# Consultation Outcomes Report

Narwee Parklands Care Community

Prepared on behalf of Opal HealthCare

### 6.1 Council feedback

1 SITE ELEVATION - NORTH
1 : 300

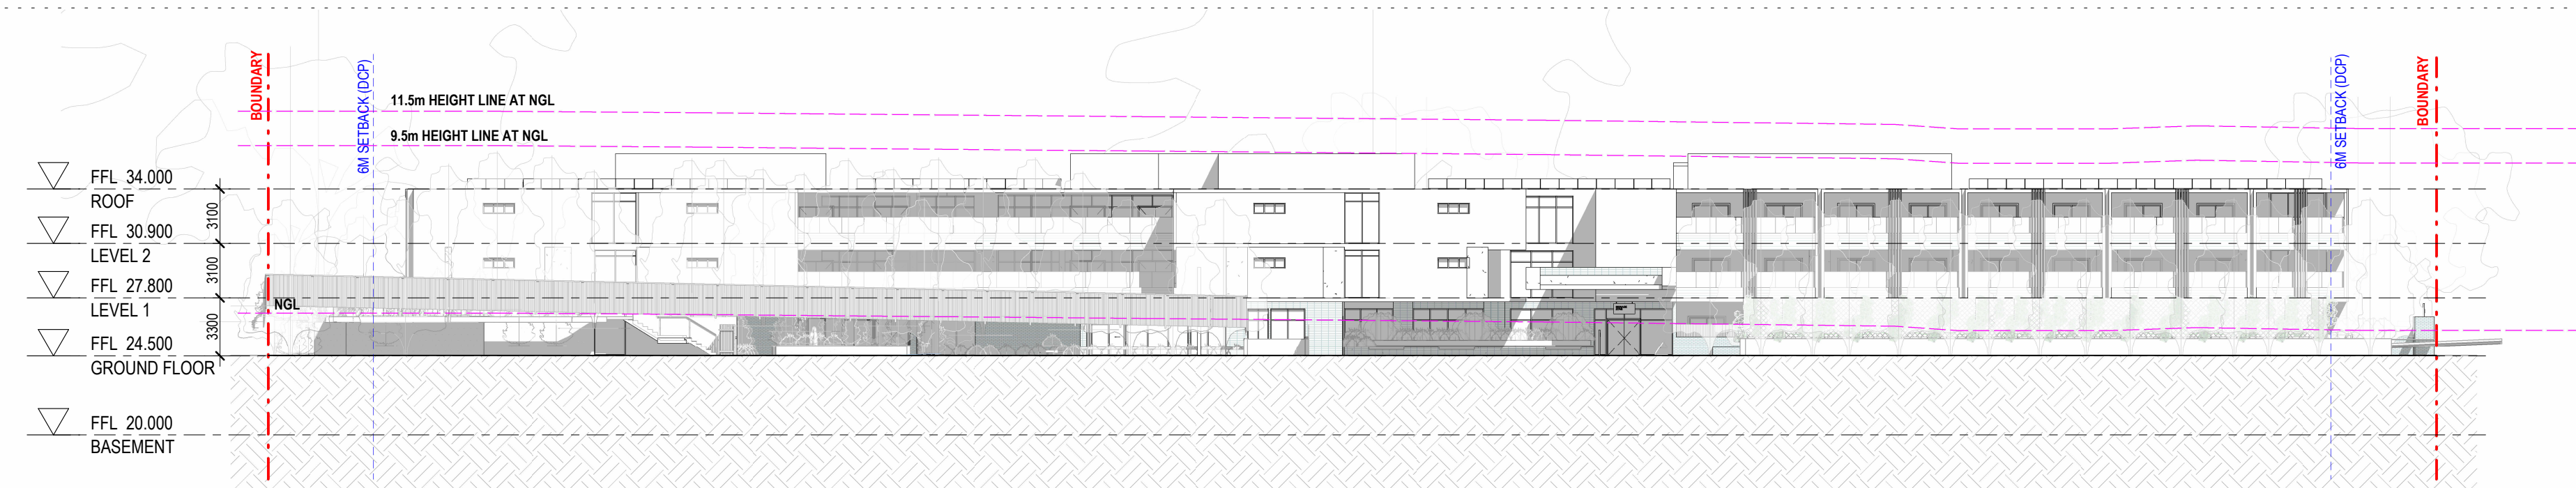
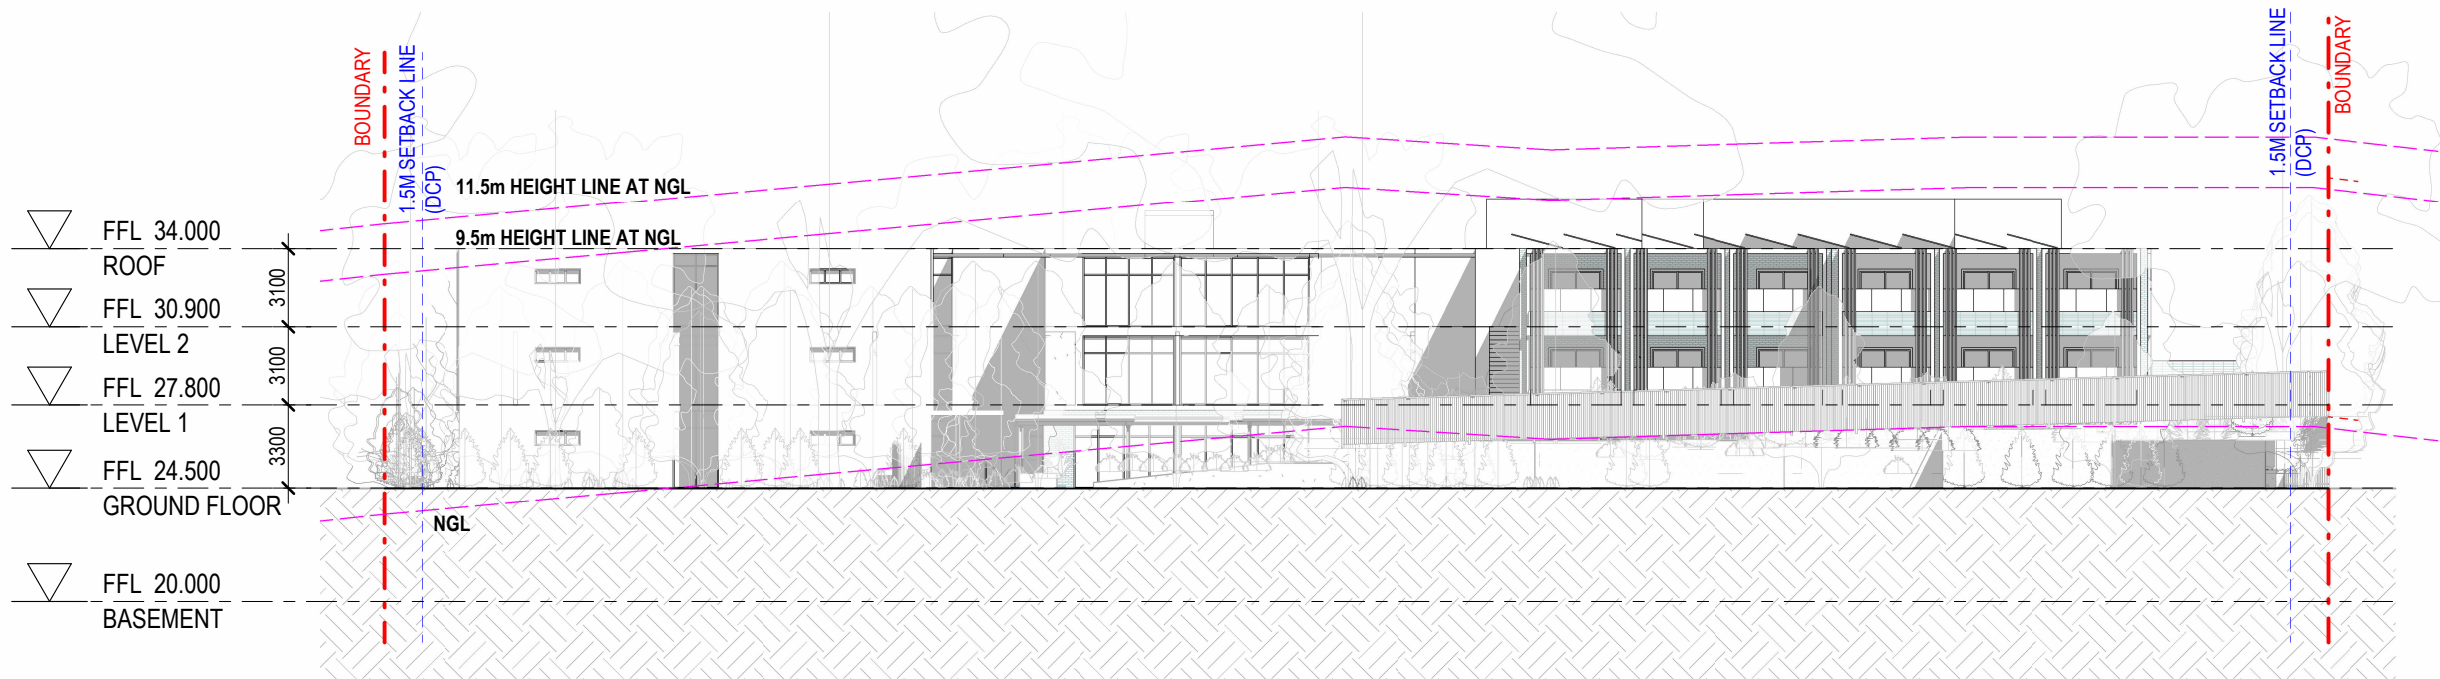
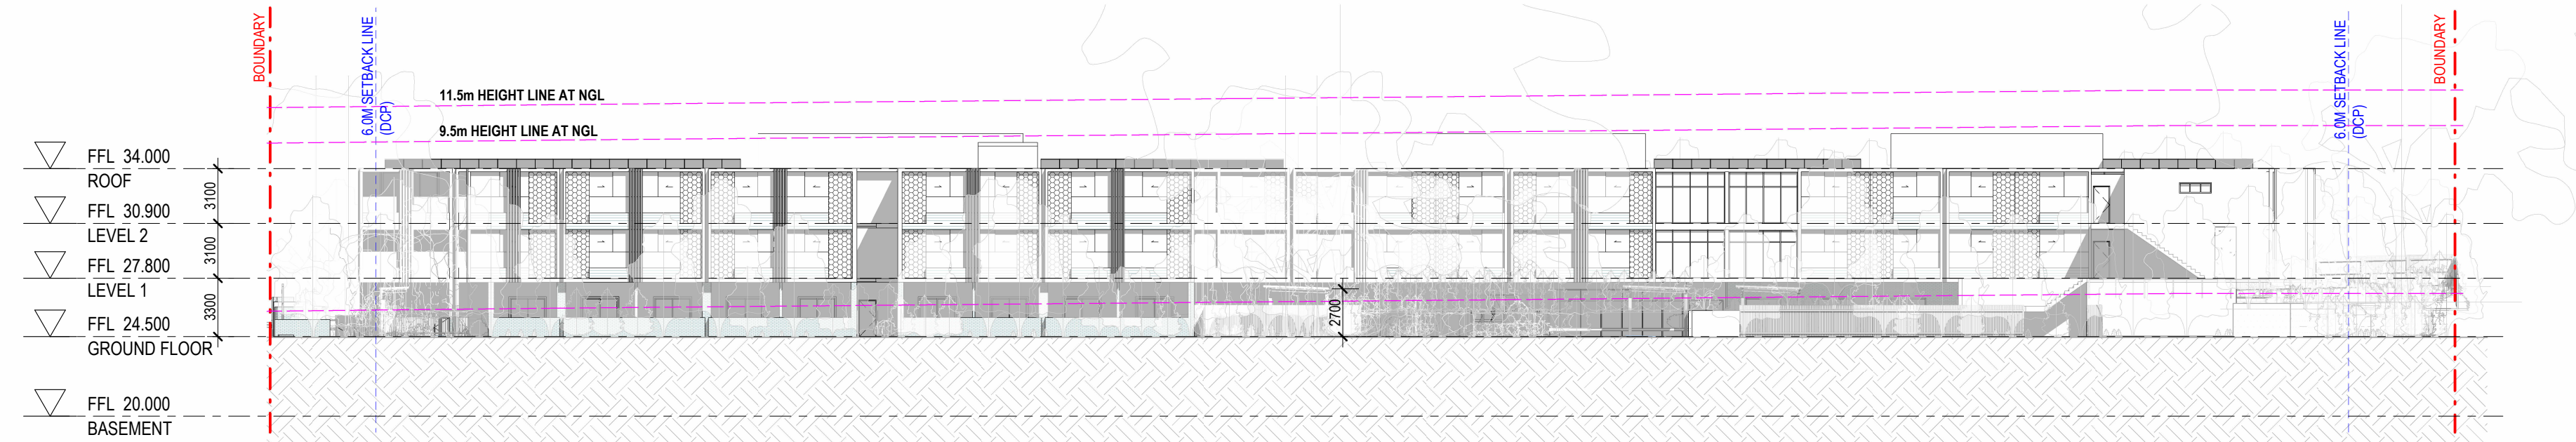
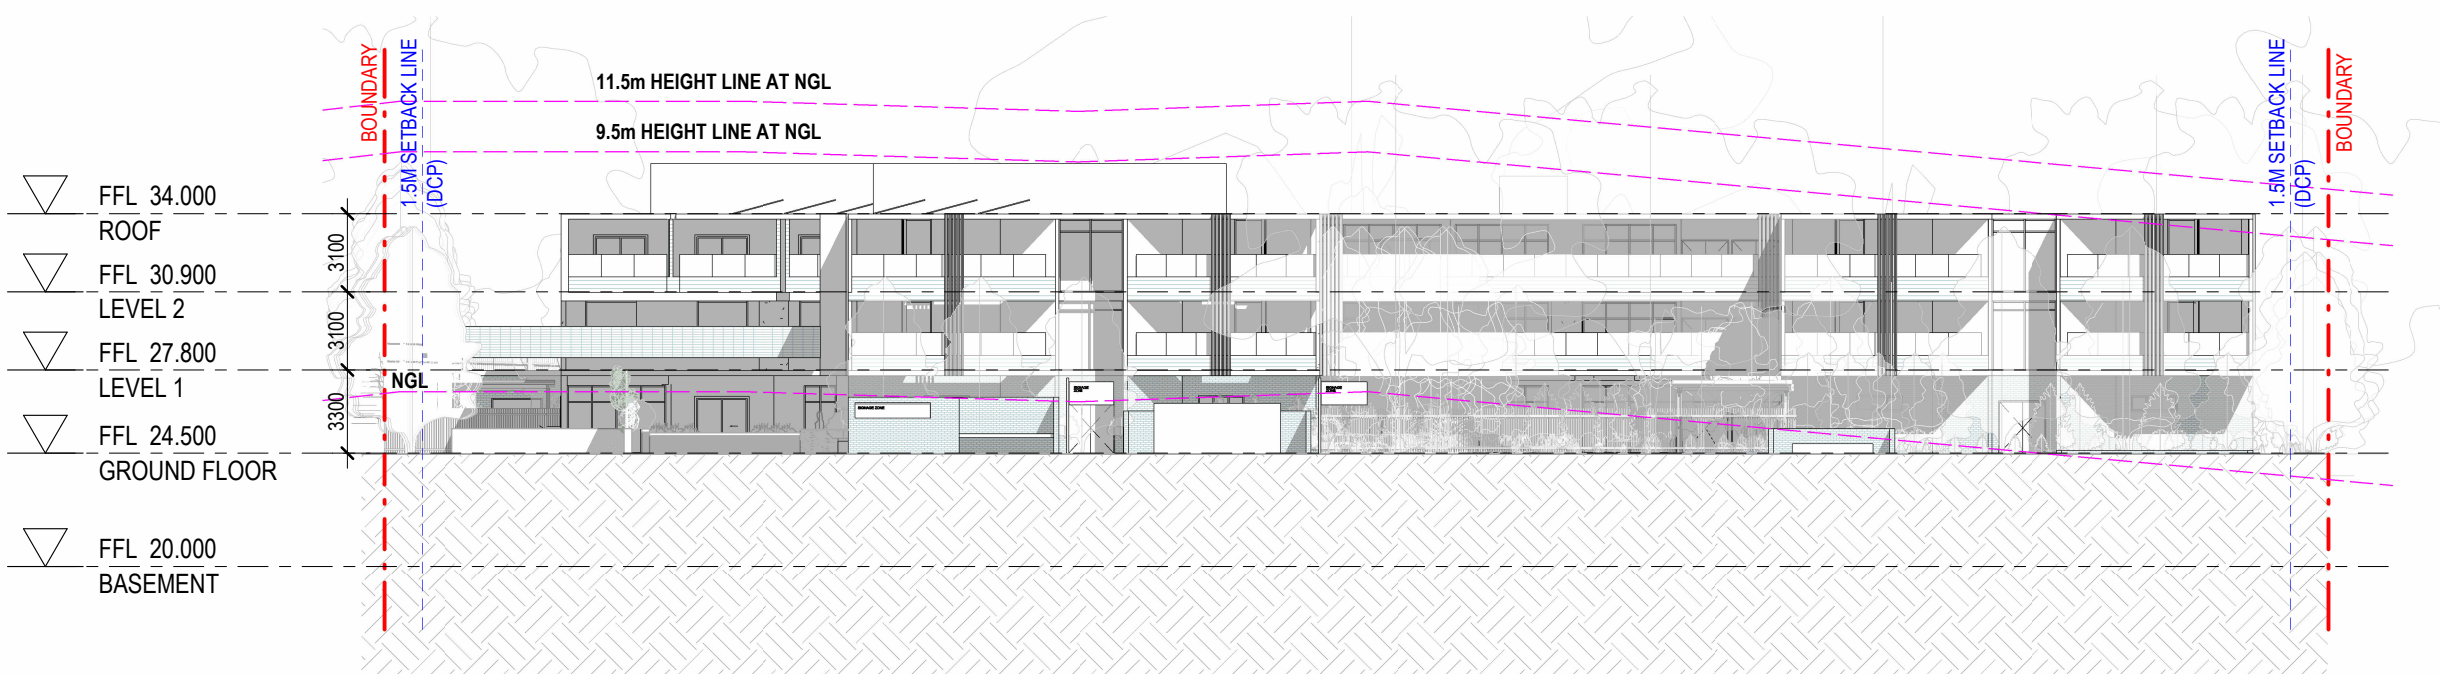
Topic	Summary of feedback	Project response
Streetscape and public domain interface	<ul style="list-style-type: none"> <li>Provide Karne Street elevation showing the relationship to the surrounding context and demonstrating appropriate bulk and scale.</li> <li>Buffer the interface with the dog park.</li> </ul>	<ul style="list-style-type: none"> <li>The proposal has been designed to address Karne Street North, with the vehicular and pedestrian access points facing the street. The built form has the communal landscaped area and bedroom windows facing the street which will allow passive surveillance to the street and public domain.</li> <li>The proposal provides ground floor setbacks varying from 1.5-7m and upper floor setbacks to the north facing the neighbouring residential dwellings varying from 7-9.9m, ensuring that the built form steps away from the site boundary and is well separated from neighbouring development. A garden facing the north of the site and other landscaped area further recesses the building and provides articulation to the building façade which reduces the appearance of built form.</li> <li>Further, the development is situated to the south and west of residential dwellings which ensure that over 3 hours of sunlight is provided to the dwellings and private open spaces of neighbouring development.</li> <li>A fence is proposed to the site boundary adjacent to the dog park.</li> </ul>

1 LANDSCAPE INCLUDING BIODIVERSITY

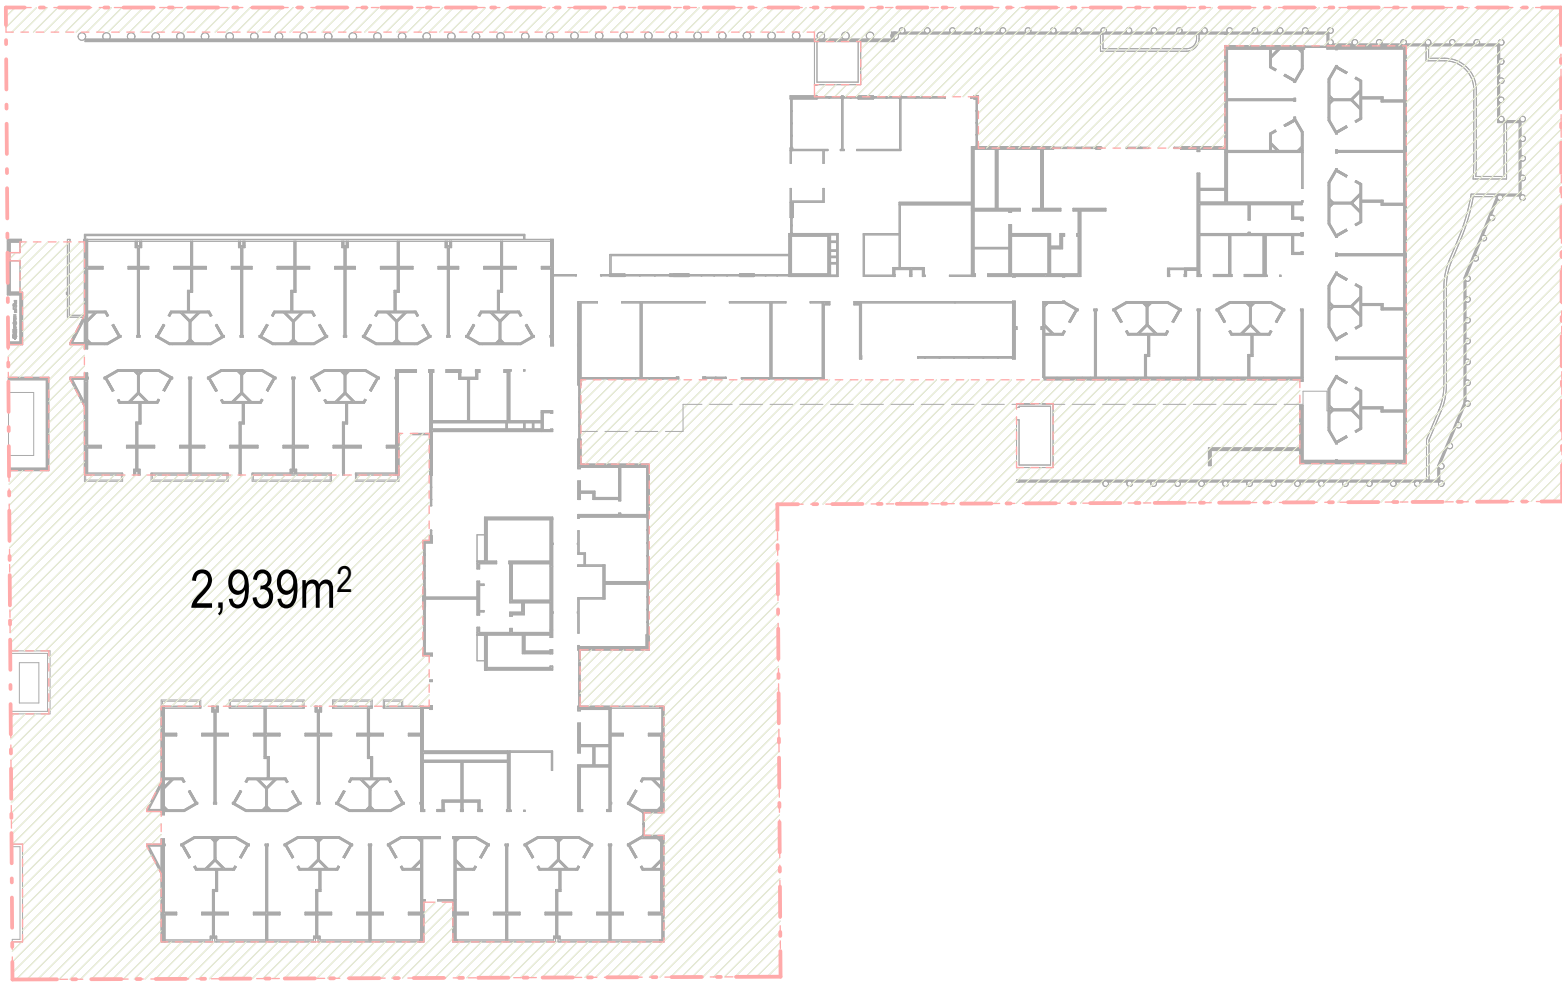
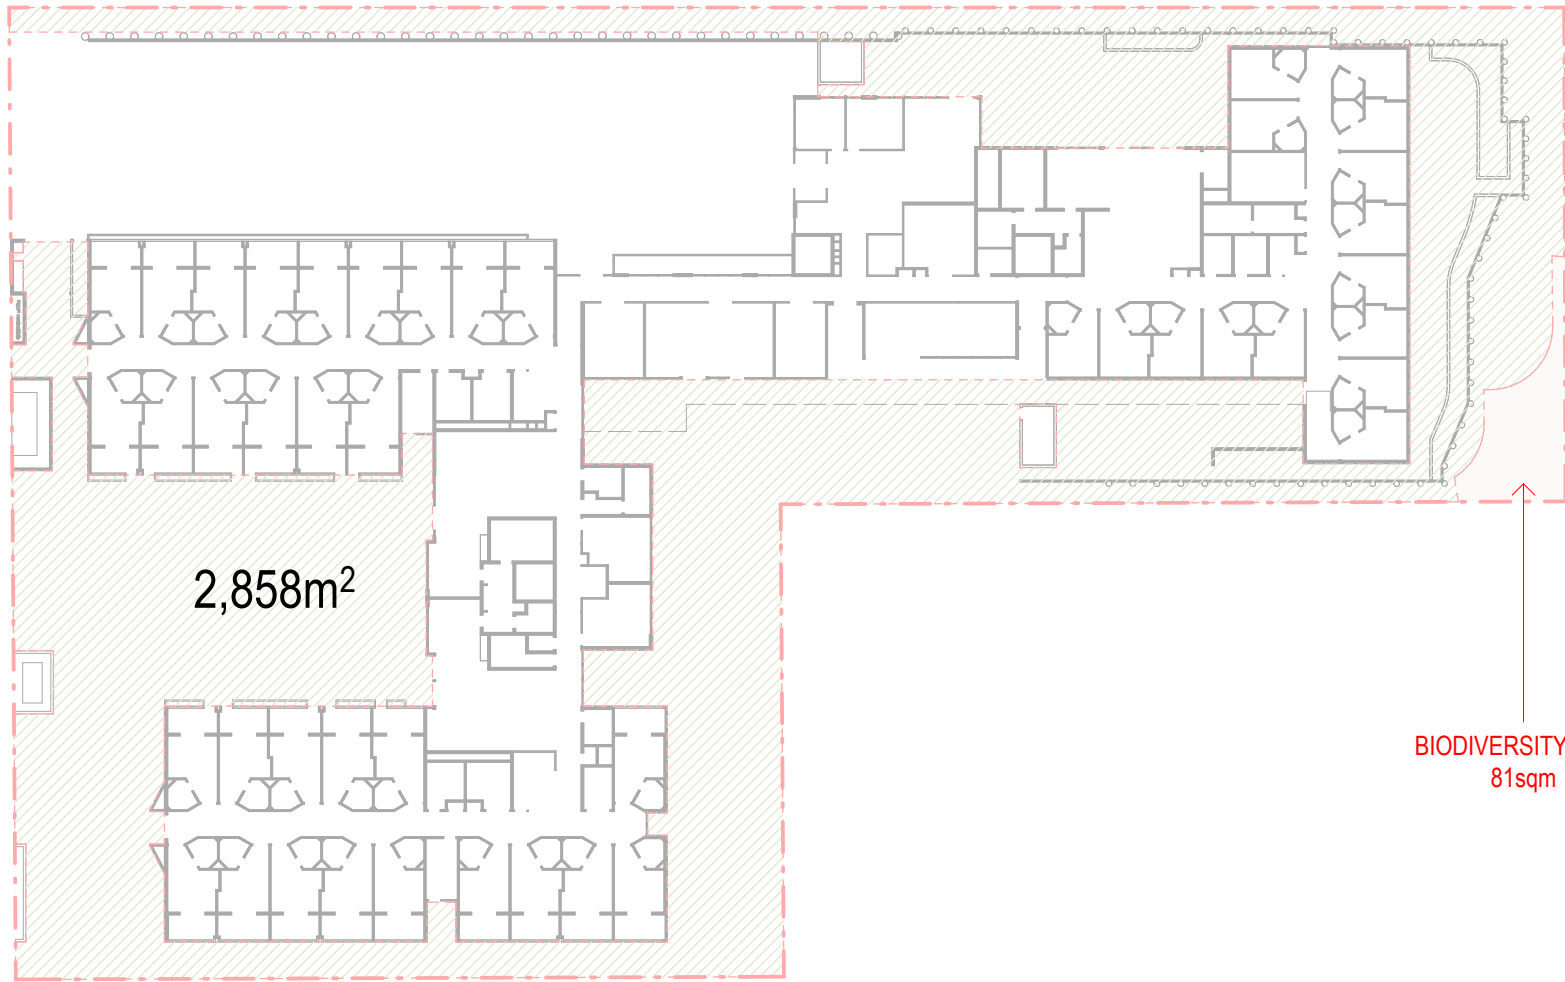
Environmental management	<ul style="list-style-type: none"> <li>Arborist report and any other environmental assessments to be provided.</li> <li>Consider a potential third layout option that retains trees 6 and 7.</li> <li>Vegetation on the Biodiversity Values Map is significant and must be retained and protected, with no encroachment to the tree protection zone.</li> <li>A surcharge pit draining water onto Council land is not supported.</li> <li>Tree planting to reflect prevailing species and the Castlereagh Ironbark Forest Ecological Community.</li> </ul>	<ul style="list-style-type: none"> <li>An Arborist Report and other environmental management documentation have been provided as part of this application.</li> <li>Tree 6 has been retained as part of this application, with tree protection zones and other measures provided to retain this tree.</li> <li>No built form encroachment to the biodiversity values area is made.</li> <li>The design of the stormwater system does not involve drainage onto Council land.</li> <li>Tree species including the quantity and size are detailed on the Landscape Plans.</li> </ul>
